Comments on Planning Application 2023/61/93714/E

[2023/61/93714/E](#)

Land off, Cumberworth Lane, Denby Dale, Huddersfield, HD8 8RU

Reserved Matters application (including the consideration of access, appearance, landscaping layout, and scale) for the erection of 10 dwellings pursuant to outline permission 2019/93906 for erection of residential development up to 10 dwellings, and discharge of condition 20 (waste arrangements)

Drawing:
 Site Plans
 As Existing

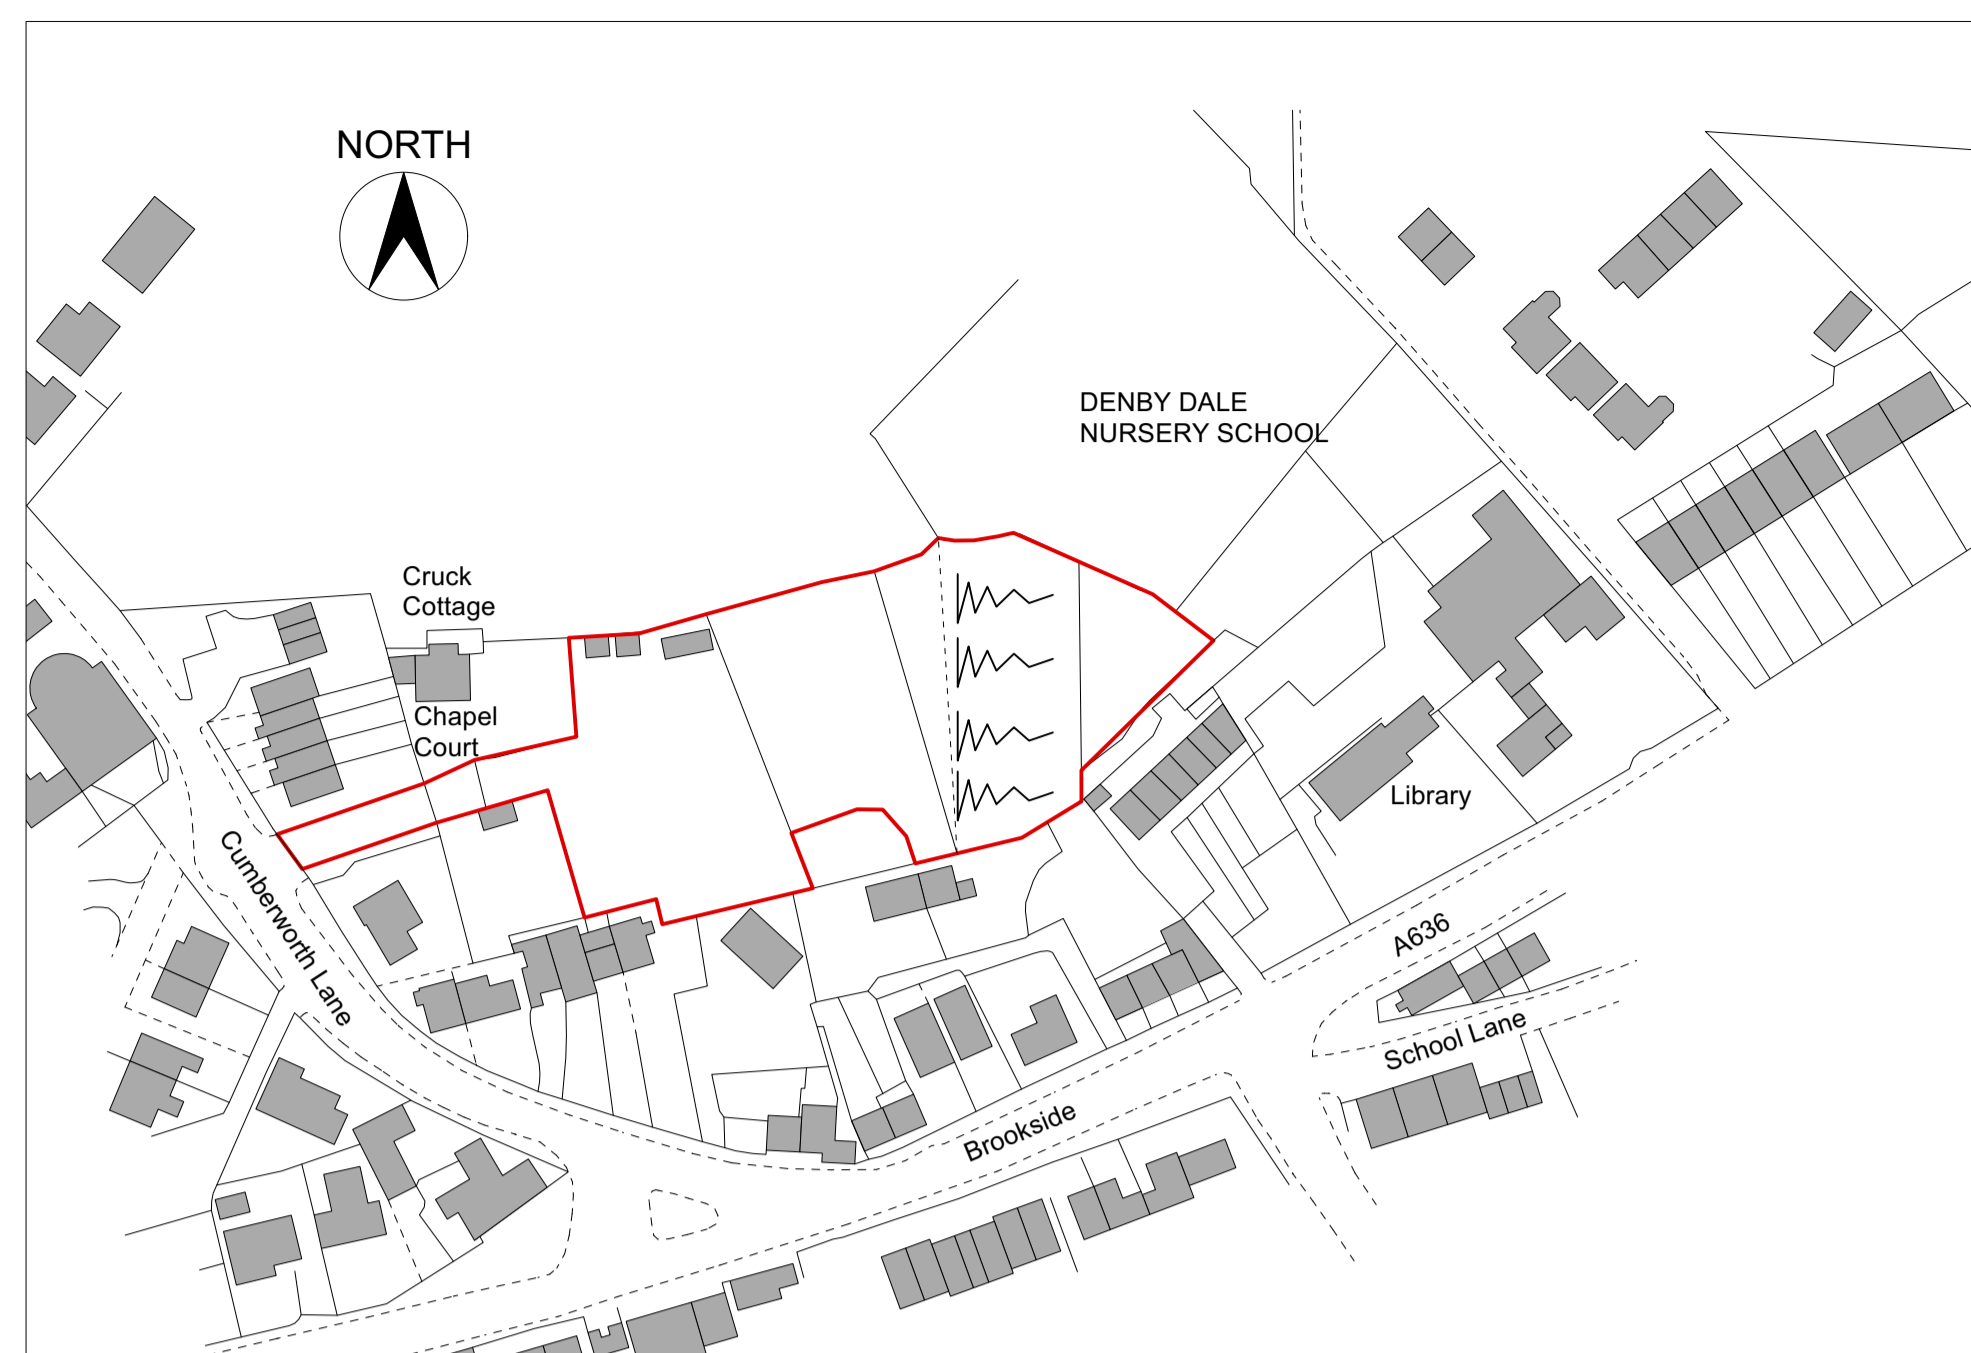
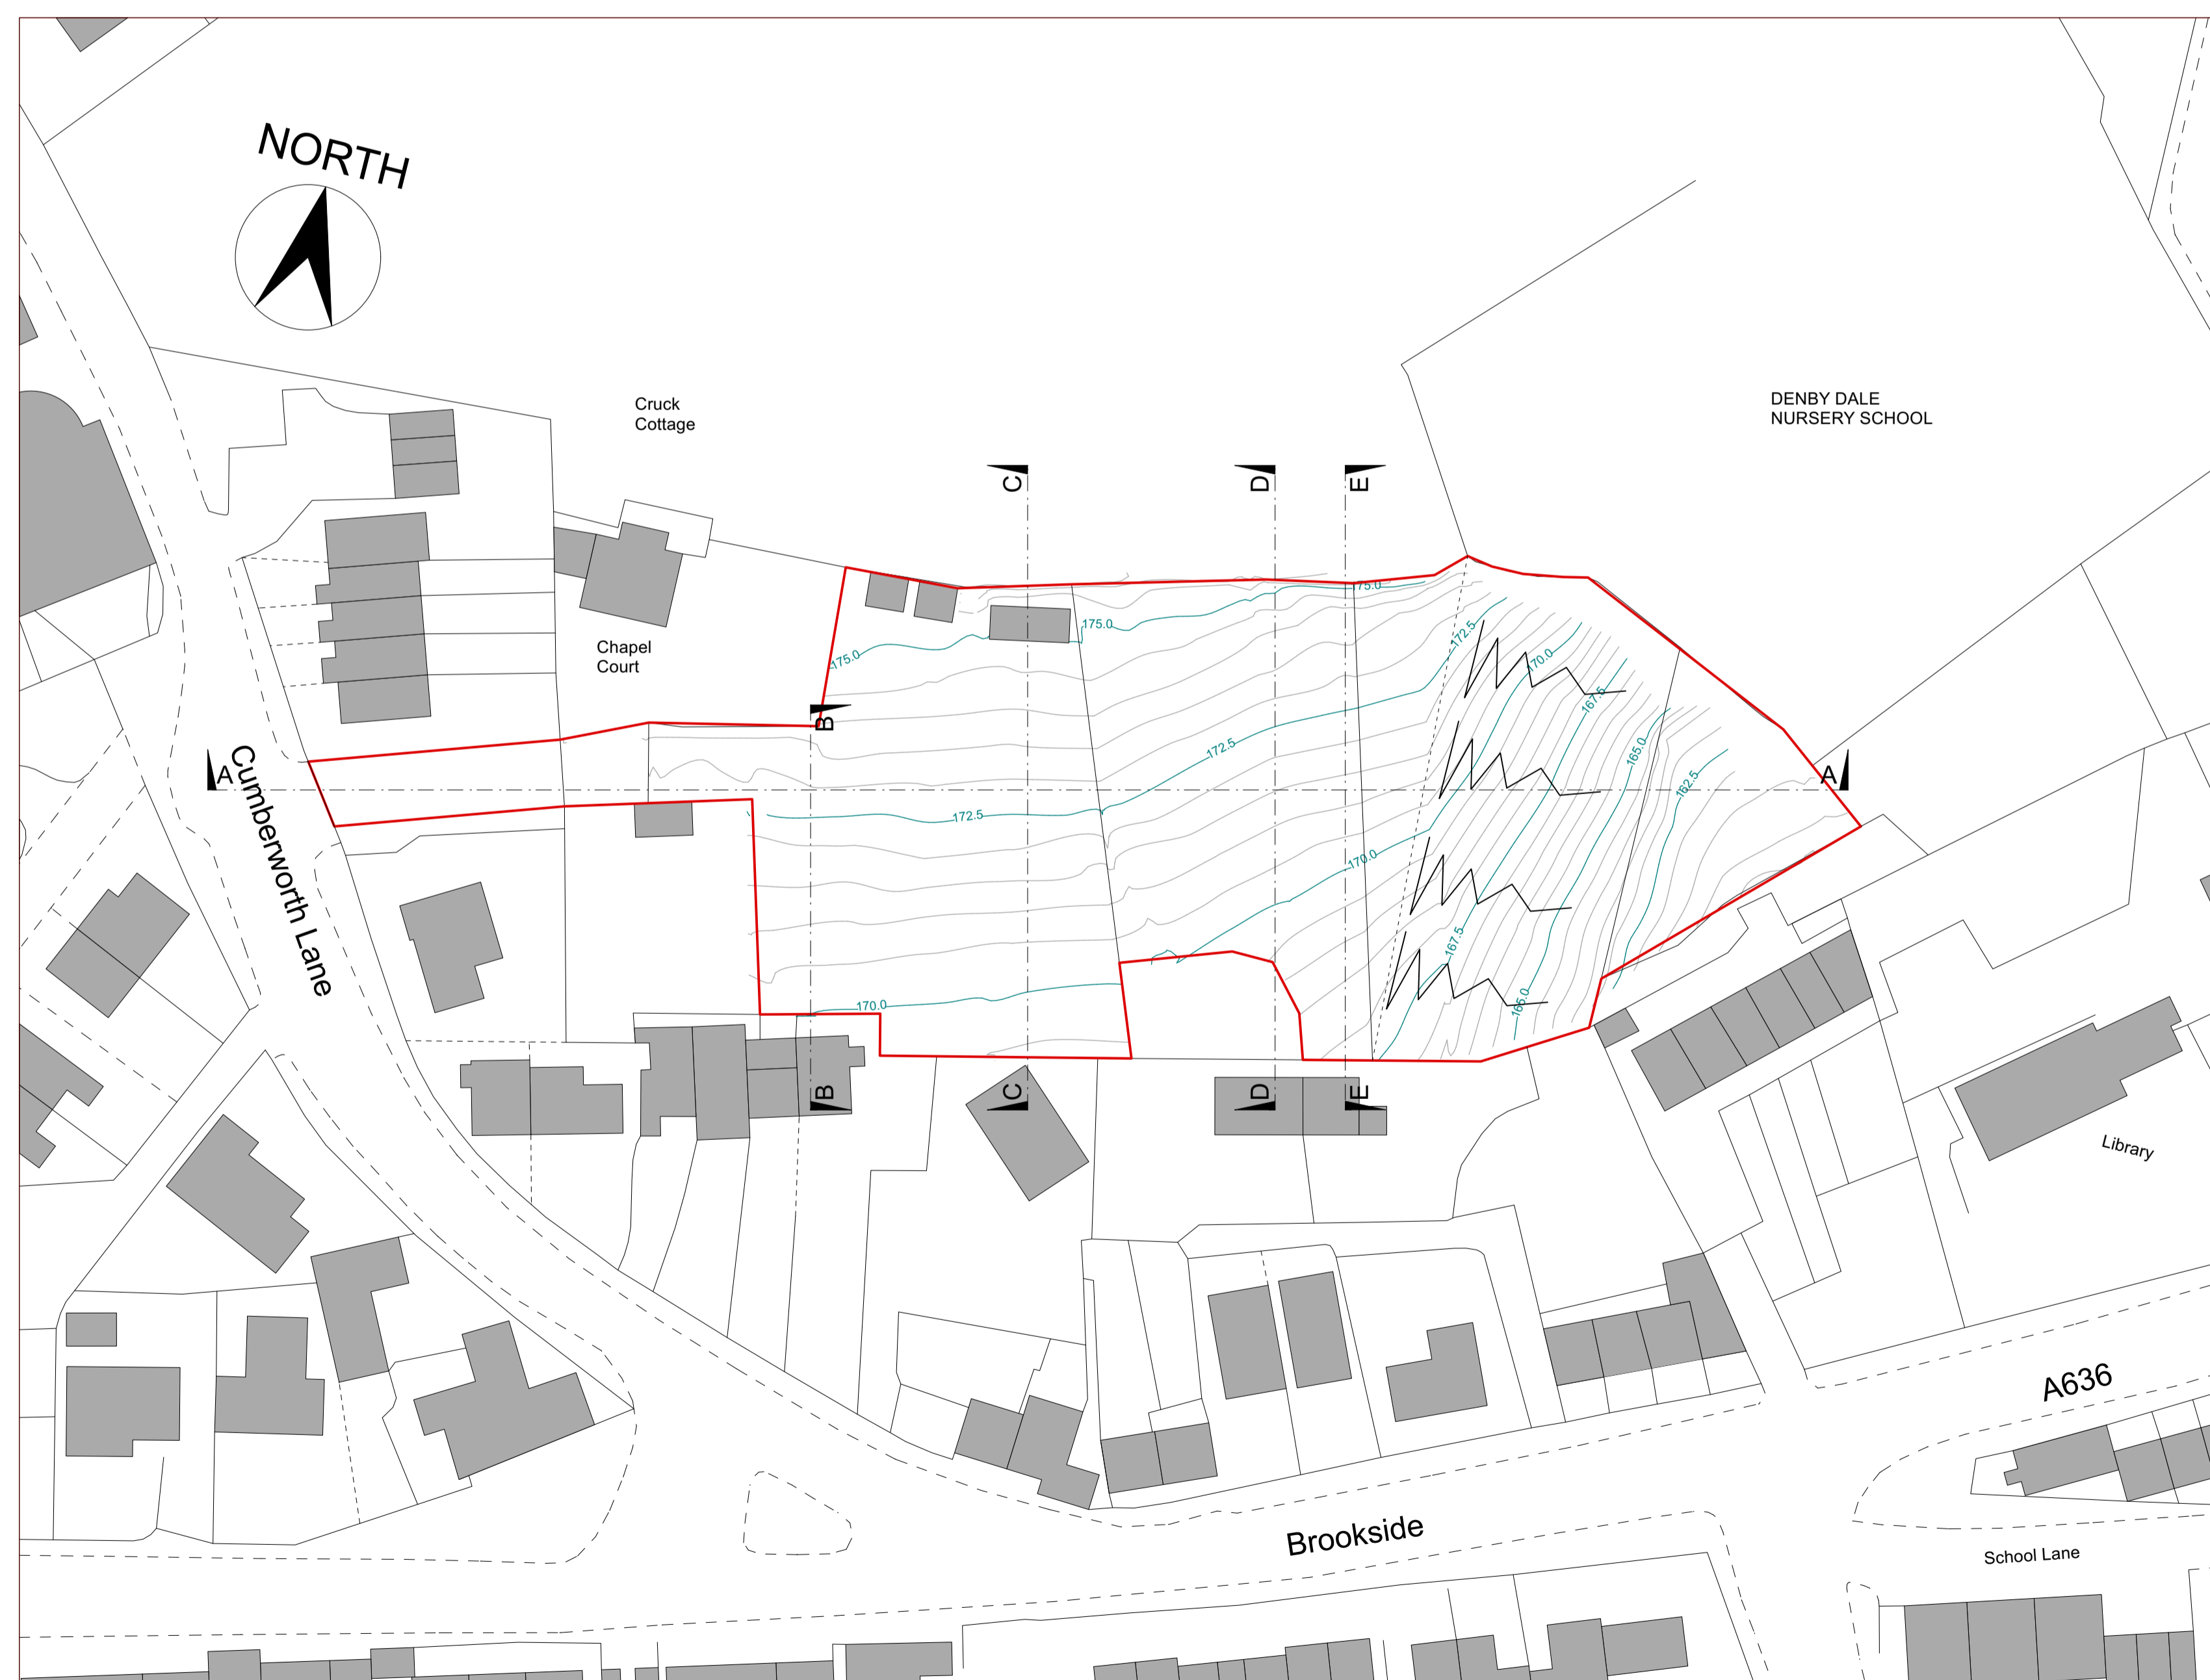
On some of the 2023 plans (as in the 2019 and 2018 submissions), the living room and second bedroom of Cruck Cottage are not shown, only the smaller older part of the house. This applies in particular to 2023-93714_ Grouped Plans and Elevations_1031054 “Site Plans As Existing”. These extensions have been part of the footprint of the property for 34 years to date. The east and south facing conservatory of this property does not appear on any of the plans or elevations.
